Re: **Mr and Mrs Stummer**

Pendle View Barn, Moorgate Lane, Dinckley, BB6 8AN

Application: 3/2022/1038.

Proposed Floor Plan - 1:100

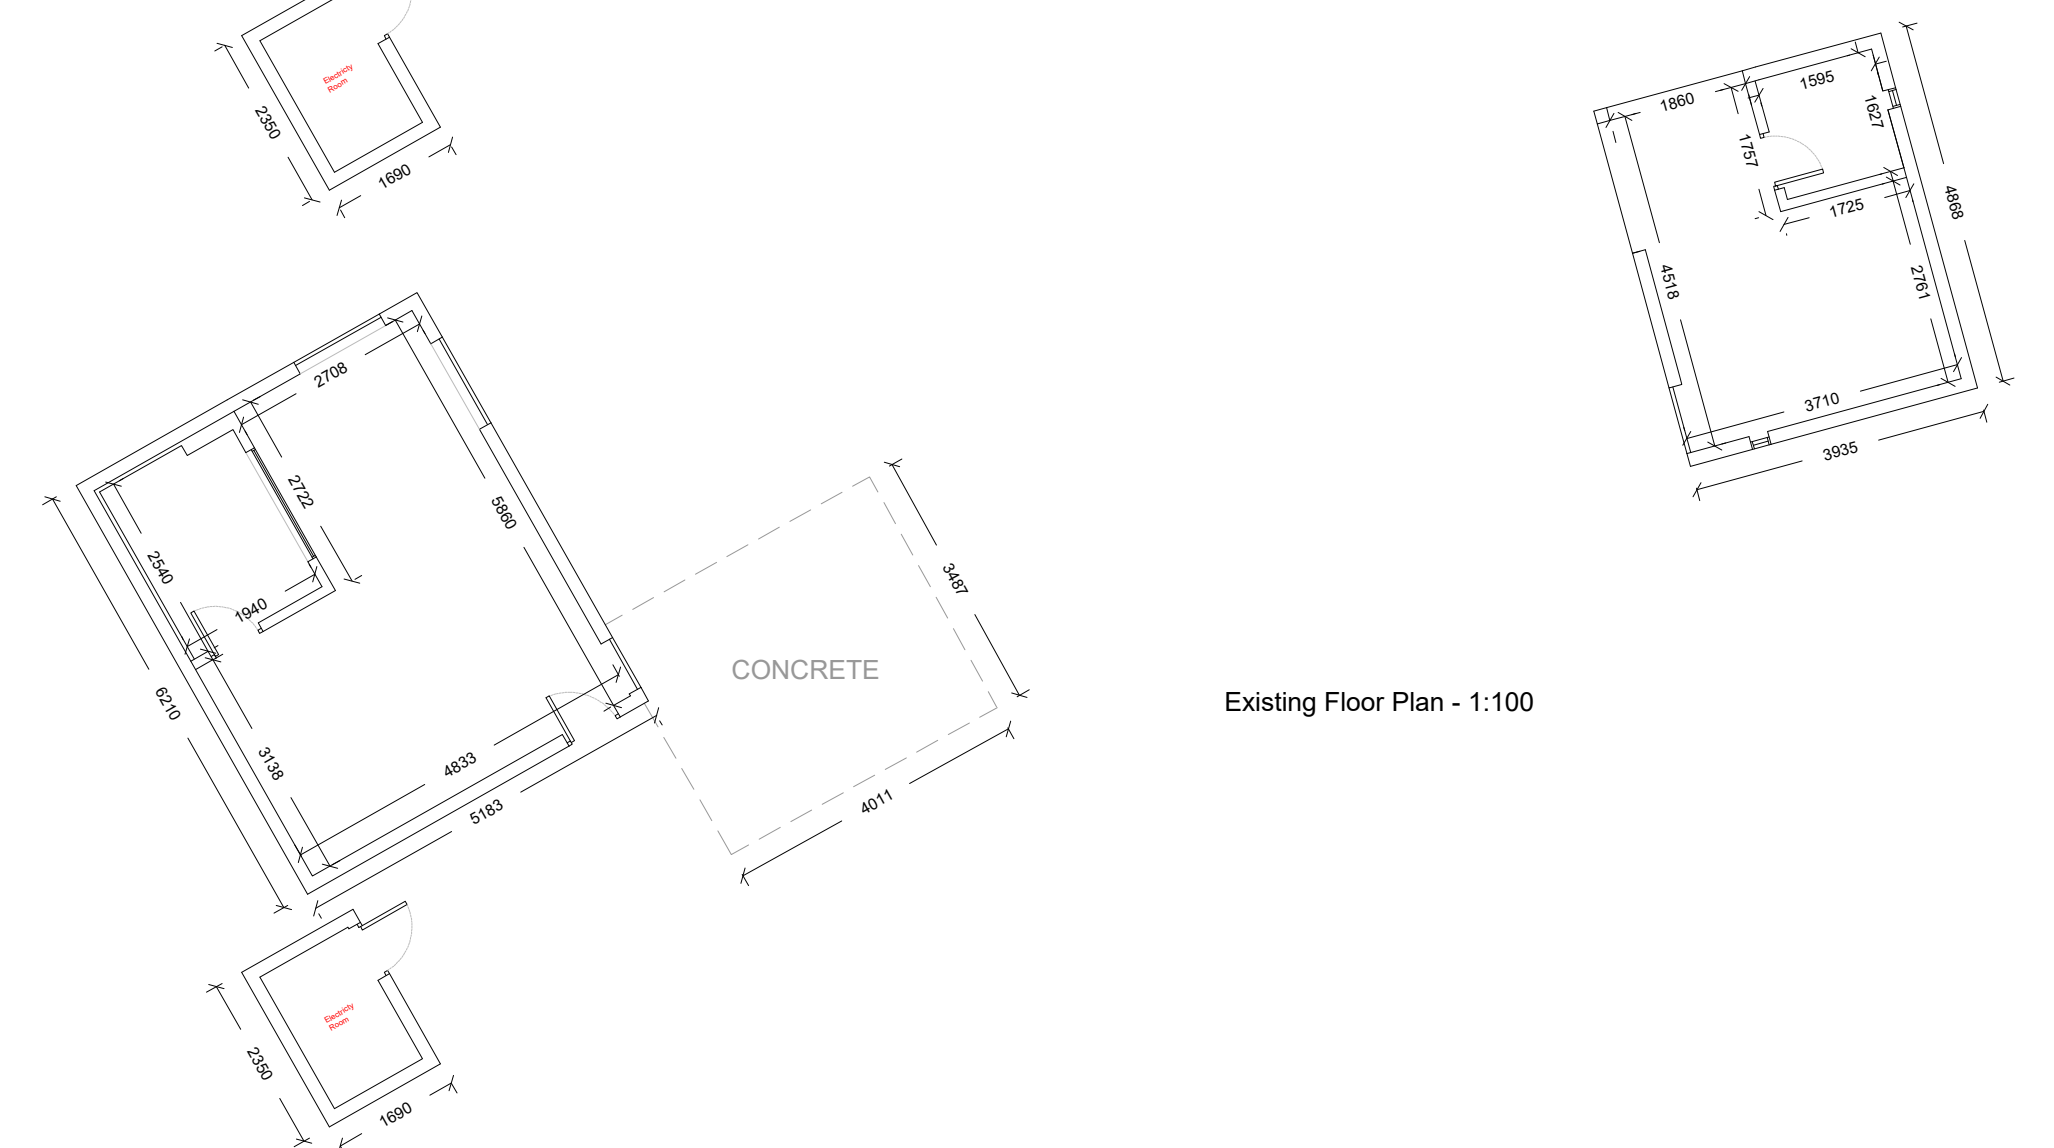
1. The original consent here for agricultural use as an allotment allowed one shed and one greenhouse, ref 3/2019/0912. At paragraph 3.1 of the current planning statement it states that two timber sheds and a greenhouse were permitted. This is incorrect. Nevertheless the applicants have also erected a third shed which encases a large container and also a fourth large shed on the larger of the two adjacent plots edged blue on the submitted plans. These seem not to be the subject of any planning application or consent.
Furthermore, the permitted garden shed and greenhouse bear no resemblance to those normal type of structures having been constructed as high quality insulated chalets fully serviced with water, electric and drainage. This enables them each now to be shown on the plans as able to contain a bedroom, bathroom and sitting/dressing area.

4. At 106 sq metres this is an exceptionally large area of living accommodation, larger than many new houses.
5. Contrary to the arguments in the planning statement many people now feel that the Ribble Valley has reached saturation point with holiday accommodation and Air B&B. Many places are rarely full and grossly under utilised. The public are turning away from staycations and reverting back to holidays abroad, a trend that is certain to increase this year.

Proposed Site Plan - 1:200

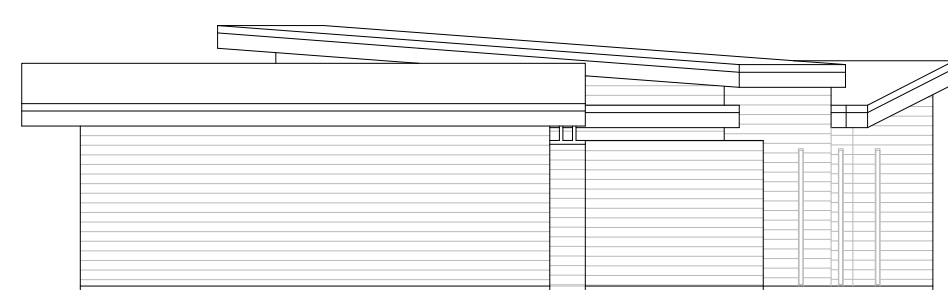
3. The access is dangerous. Kenyon Lane is a busy narrow, single track public highway and a very busy public footpath to the River Ribble and bridge across. There is a bad bend in the road here and increased turning traffic will only create a greater danger. The area is darkened by a tall, unsightly fence recently erected by the applicants stretching down Kenyon Lane which is not mentioned in the application and barely visible on the plan.

8. If granted this application is likely to be the tip of the iceberg, leading to applications for further chalets in the three plots the applicants own. They appear to be already partially preparing the larger of the two plots edged blue on the plan by erecting another wooden chalet there and a very tall unsightly fence down the roadside which now carries two electric cables presumably to light the area and probably also for electric to the further chalets no doubt planned for that area.

10. It's understood that underground tanks are already in place under this site so it is essential they and any new tanks are shown on a plan and the pipes to and from them. Strict rules apply to the siting of tanks and discharge has to be 10 metres away from water courses, the building or any residence and 3 metres away from the boundary and any tree roots. All this seems unlikely to be achieved on this small plot if these or other tanks are for sewage. There is a ditch just outside this site leading to an underground pipe in the blue edged plot. Effluent discharge has to be to a watercourse with a substantial flow. This watercourse has no flow and the stream to which it drains some 500 yards away has a very low flow for 6 months of the year.
If a soakaway were proposed again strict rules apply and must be 2 metres from a neighbours boundary, 15 metres from a building and away from driveways or hardstanding areas. There is a large parking area on the site and a pond and a few metres away over the boundary into Greystones there is a large open air swimming pool so soakaways in this area, if proposed, would also seem inappropriate .
